EPC STORMWATER REVIEW COMMENTS
IN ORANGE BOXES WITH BLACK TEXT

LES SCHWAB TIRE CENTER GRADING AND EROSION CONTROL PLAN

7105 OLD MERIDIAN ROAD FALCON, COLORADO 80831

Add PCD File No.
PPR-21-023

INITIAL GESC PLAN
C012

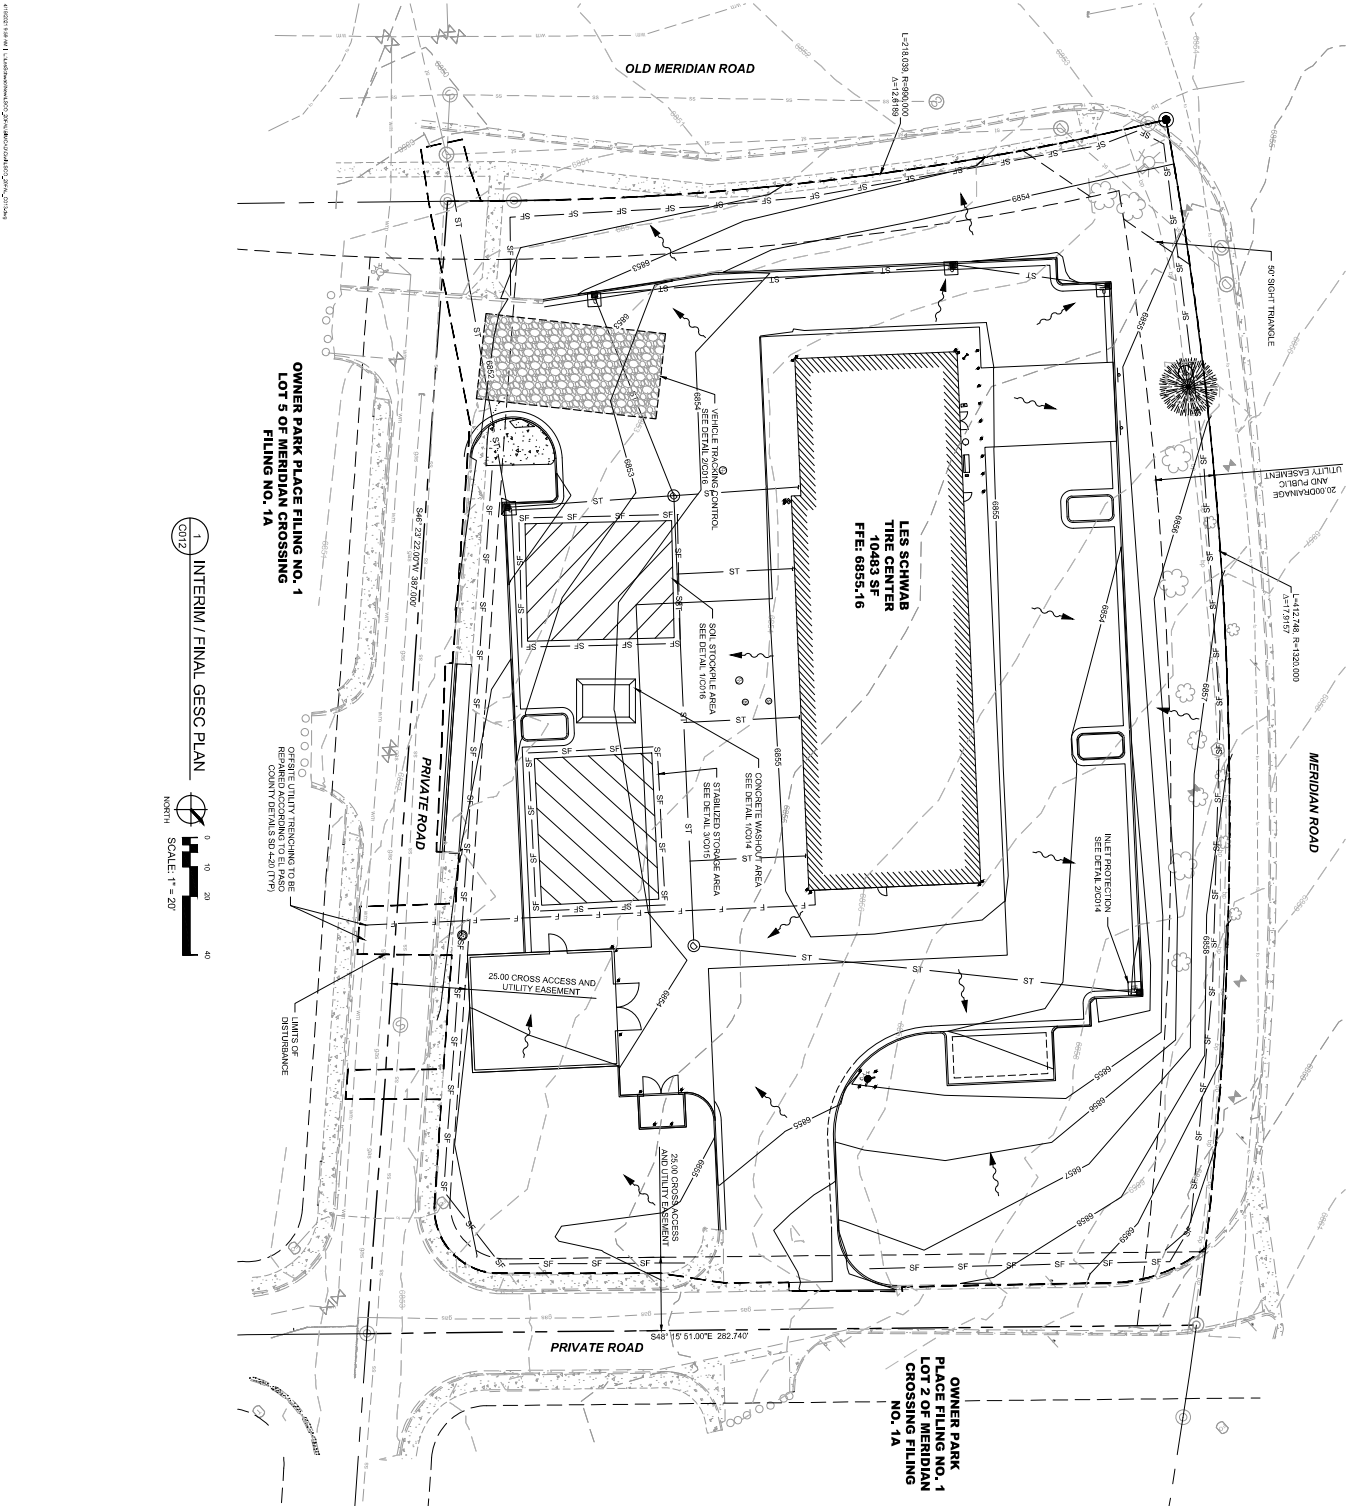
Checklist Item "p" - delineate areas of cut and fill.

Checklist Item "o" - clearly callout offsite grading. Note that the contractor may need to obtain an EPC "Work in the ROW" permit.
